**RE: PR-2019-002333 - Site Plan Review Request 5512 Buglo Ave. NW
Supplemental Information Submittal**

To whom it may concern,
Attached are revised SHEET 1 and SHEET 2 for this project. The sheets have been revised as follows:

TITLE: VIVA PARADISE TOWN HOMES PHASE II LANDSCAPING PLAN

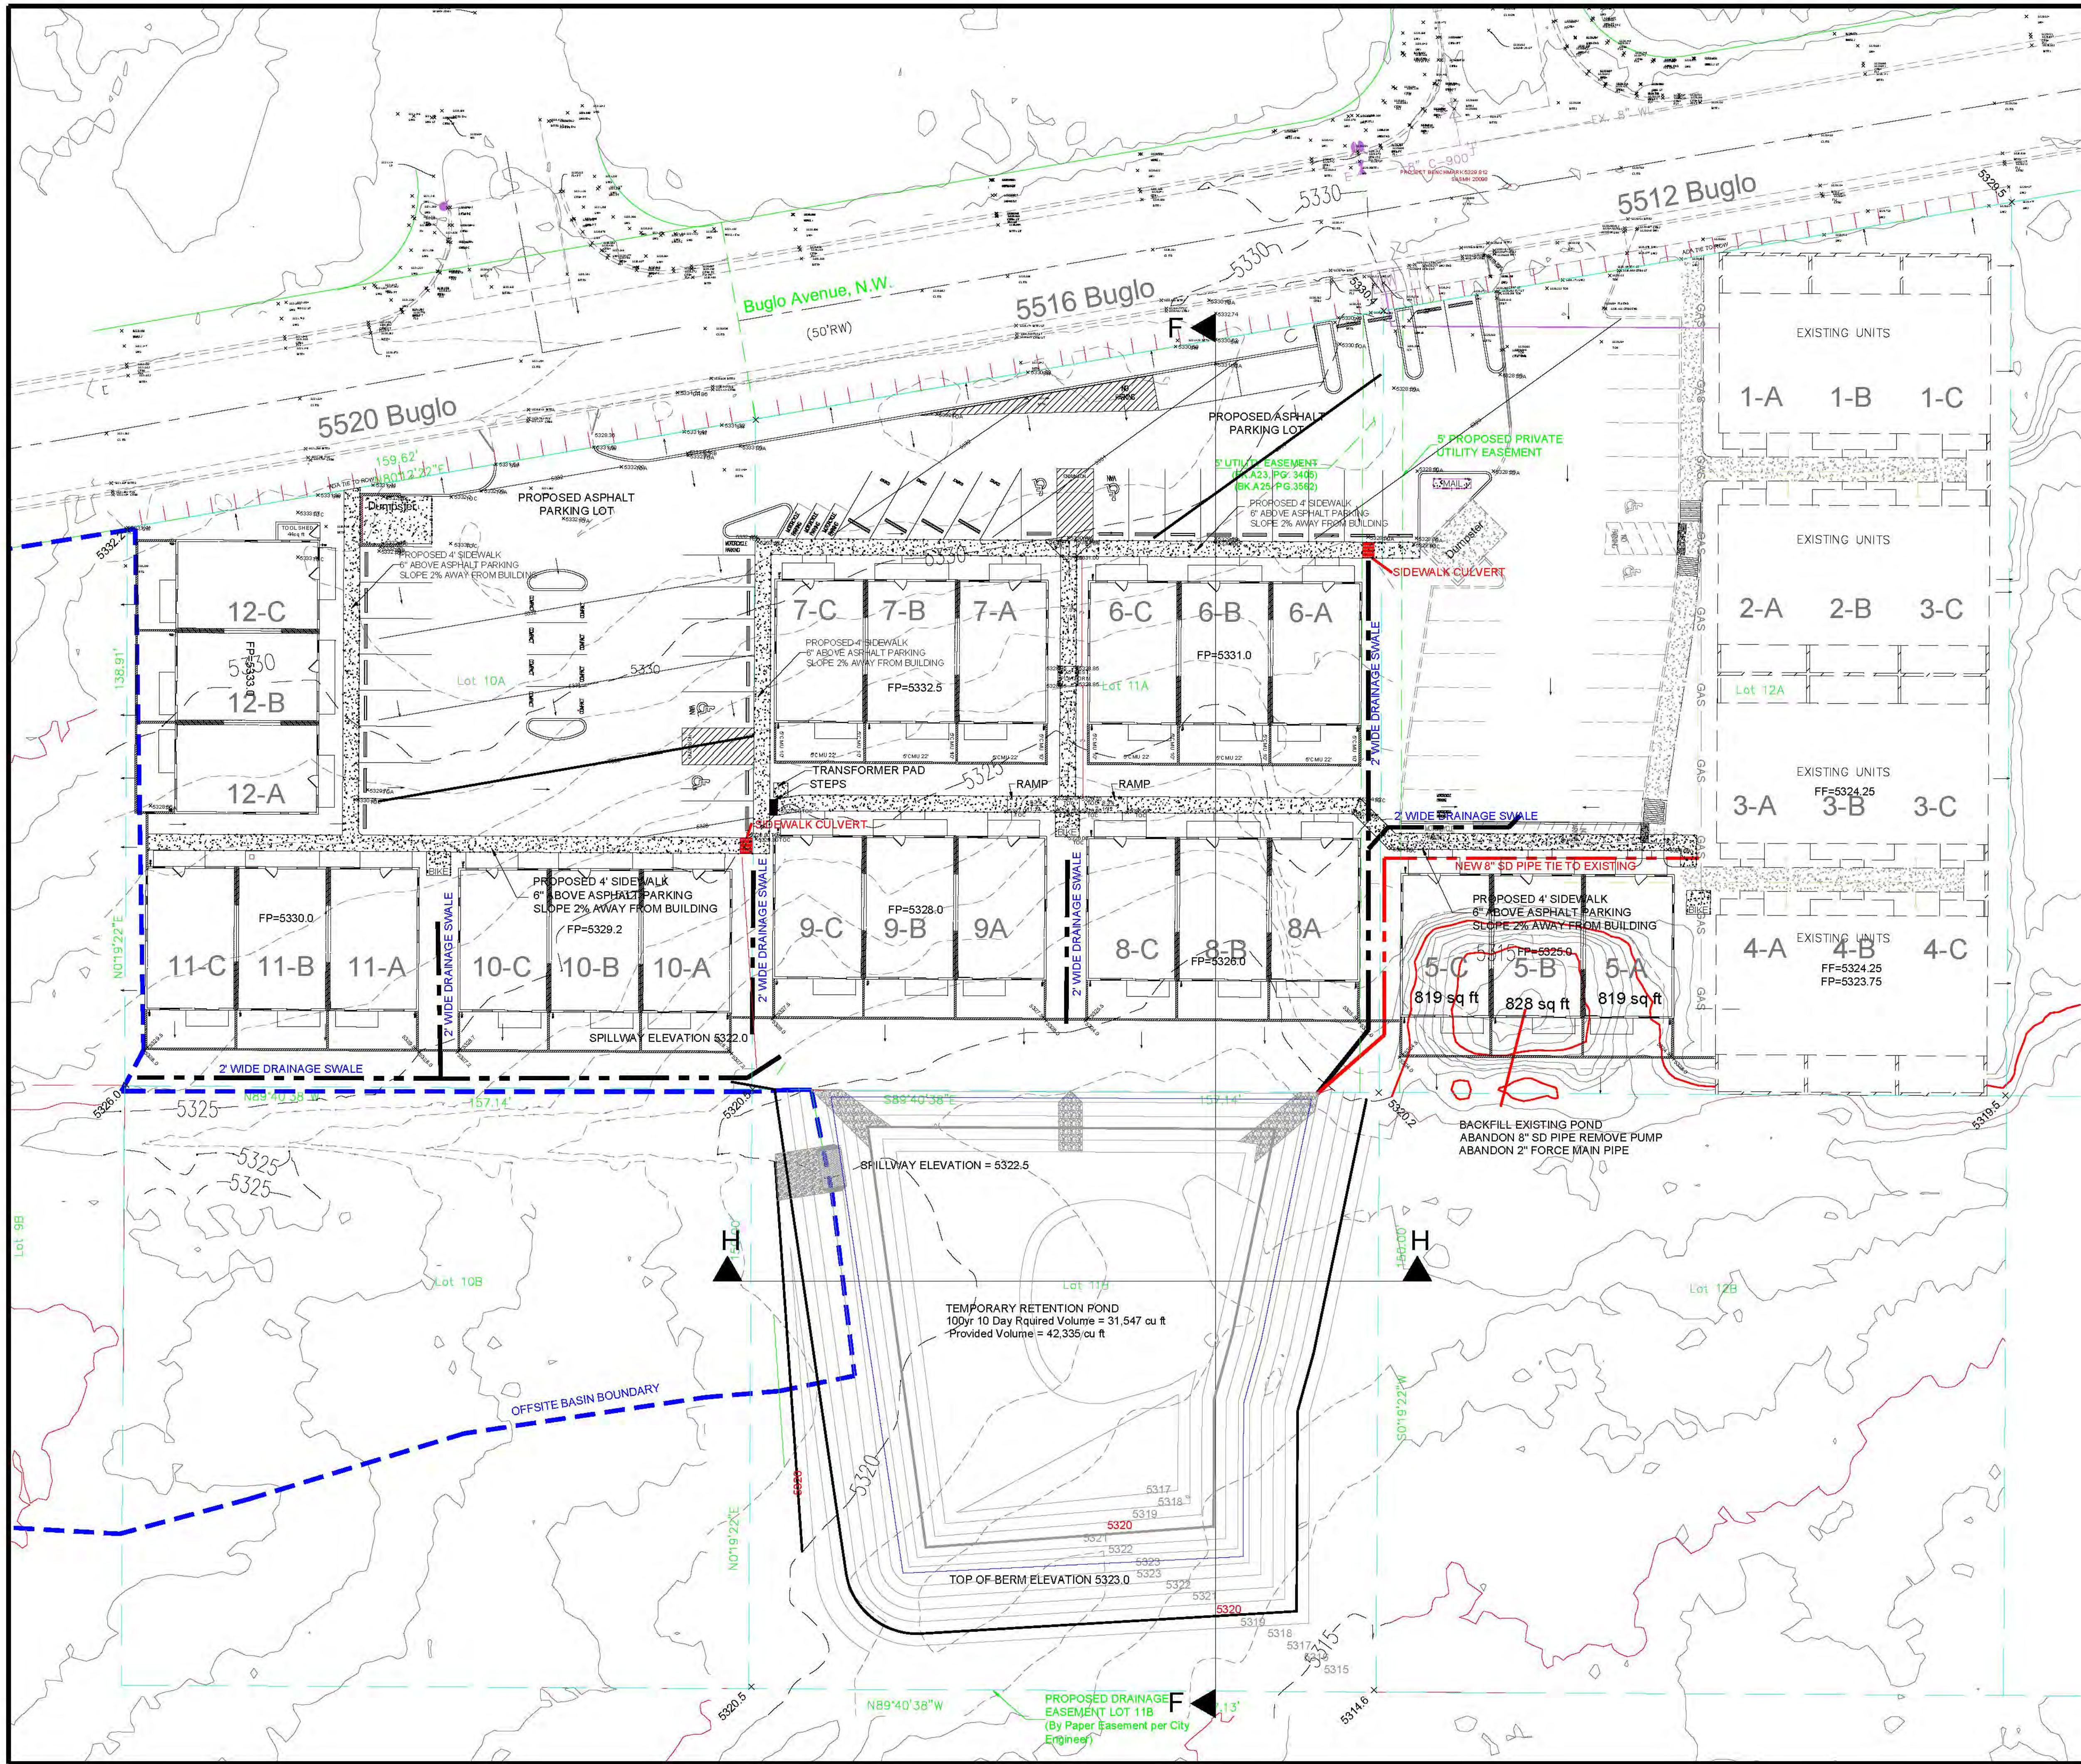
SHEET 2 – Added existing tree locations on Lots 10A and 11A.
